Letter of Intent

Ute Pass Rental, INC
8775 W. Highway 24
Cascade, CO 80906
Project Name: Ute Pass Storage Facility

Request and Justification

1 SITE PLAN
SCALE: 1"=30'-0"

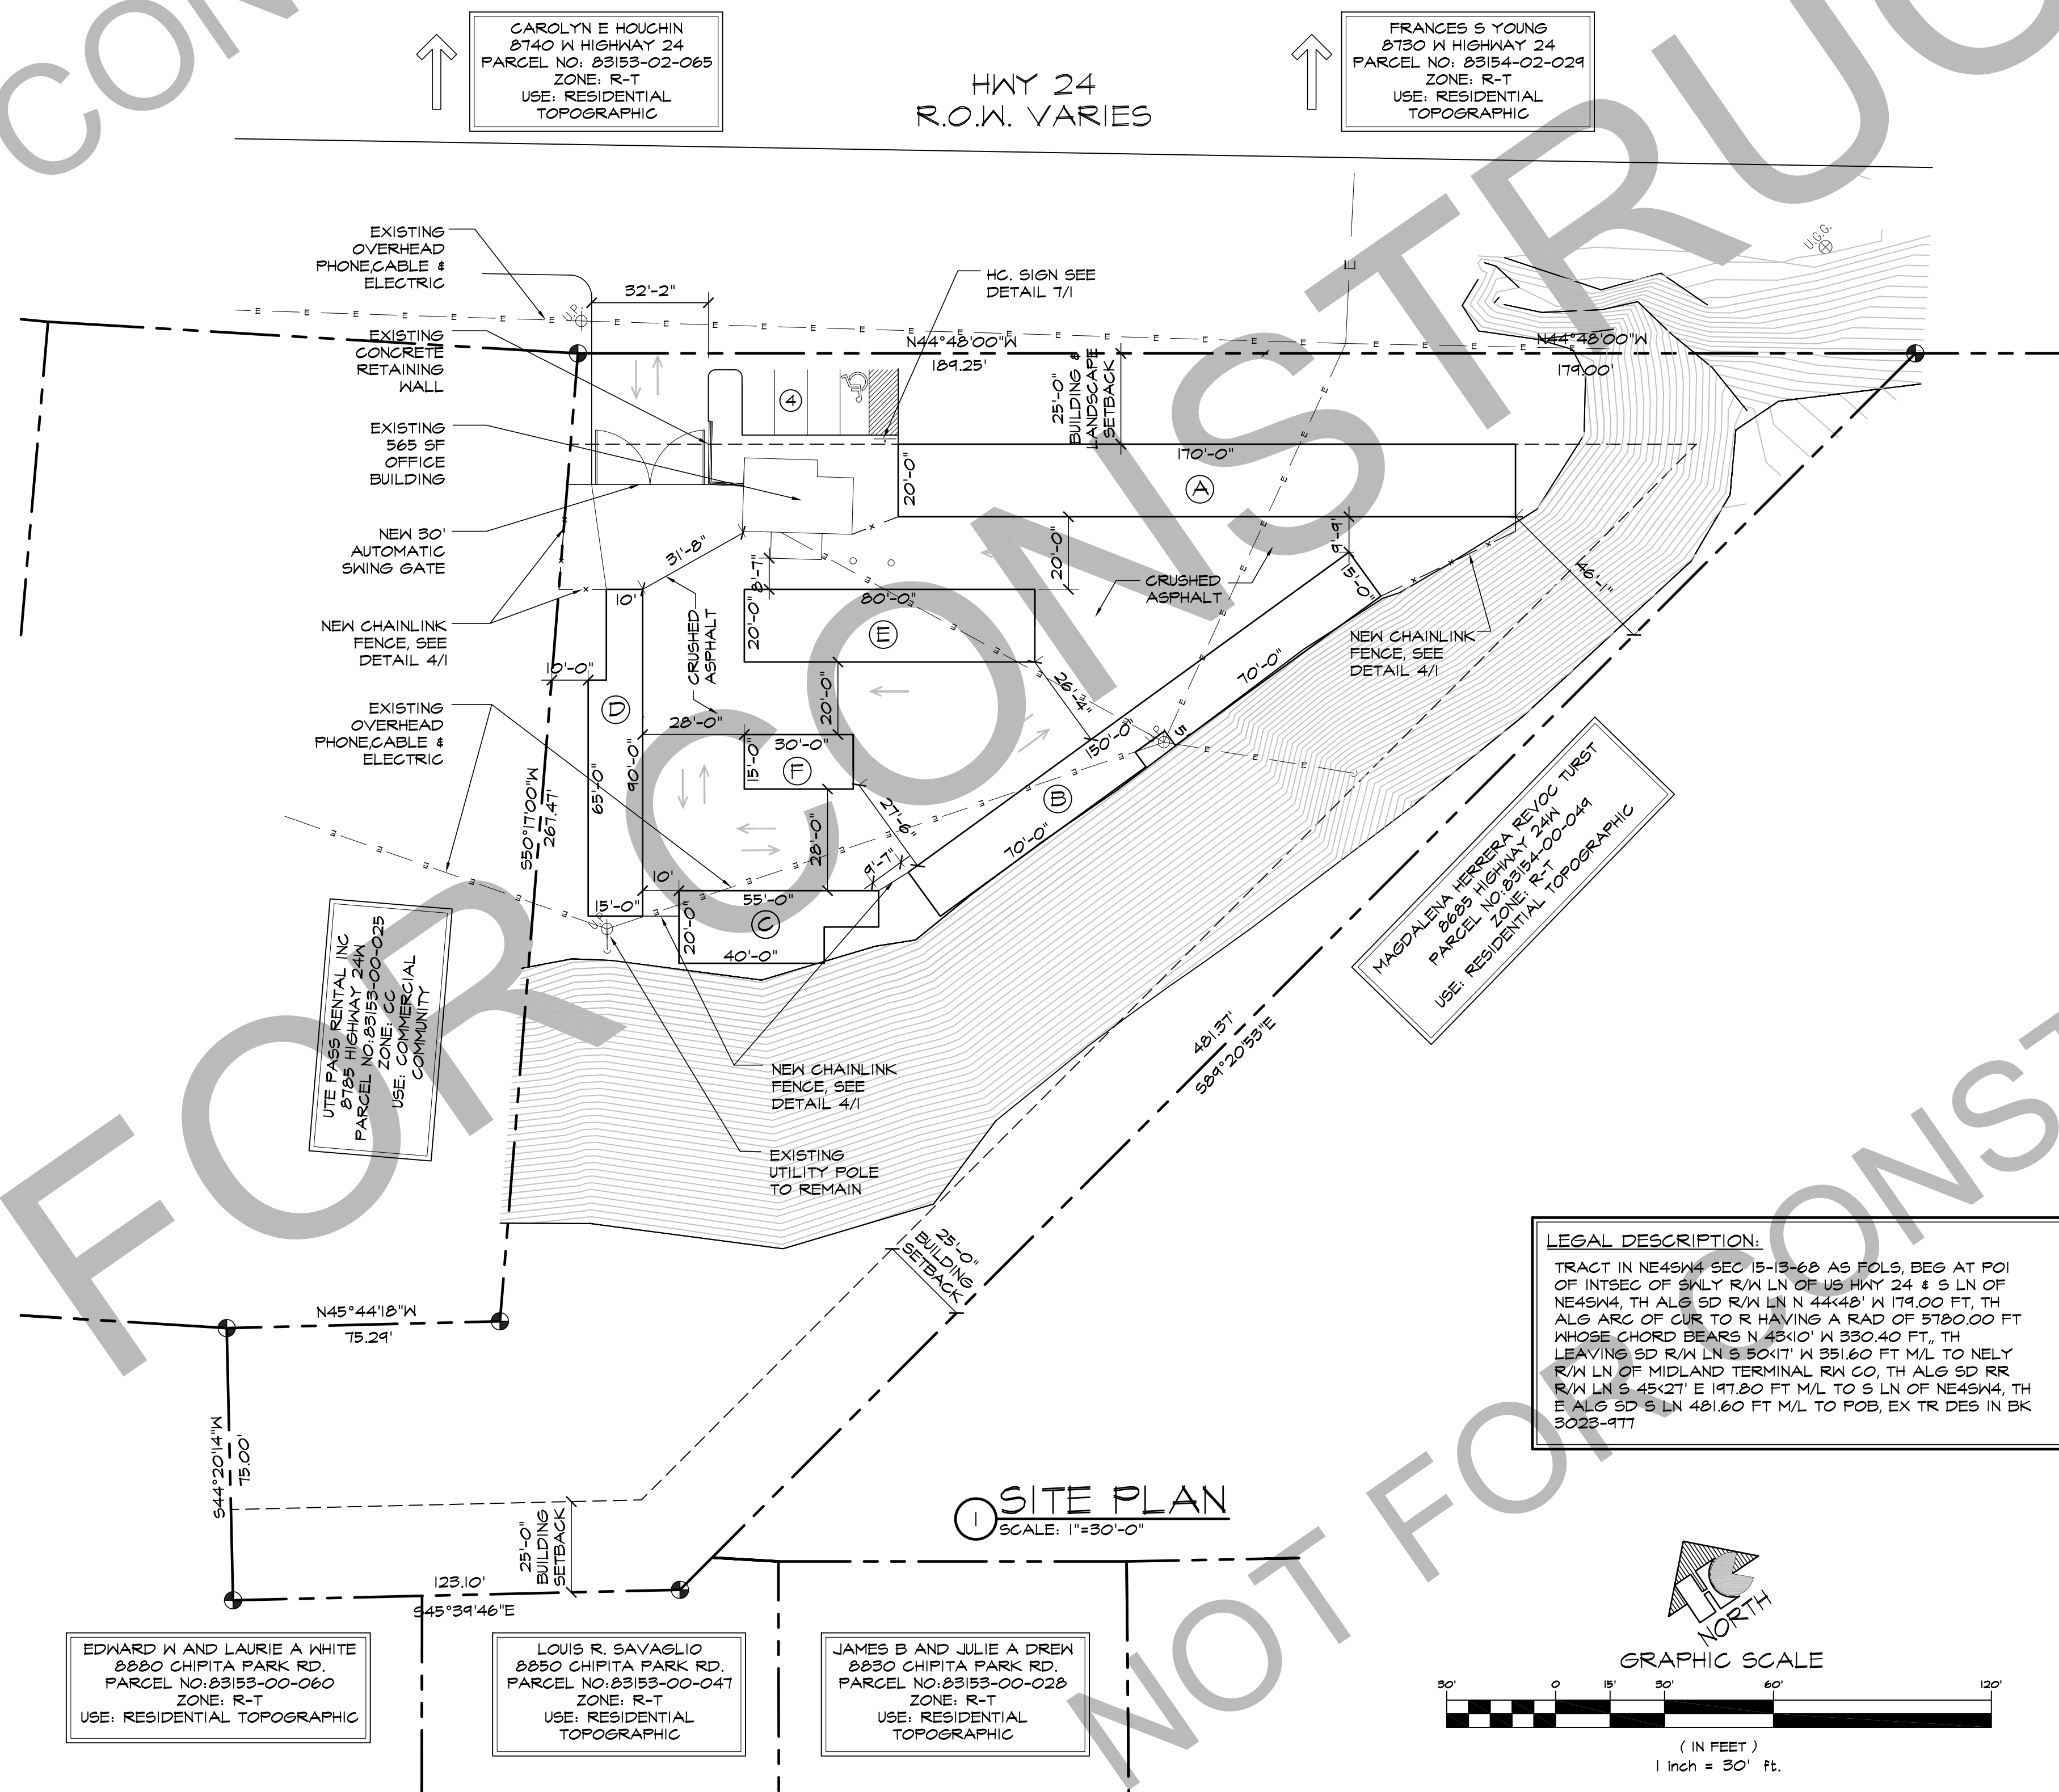
CDOT access permit
required
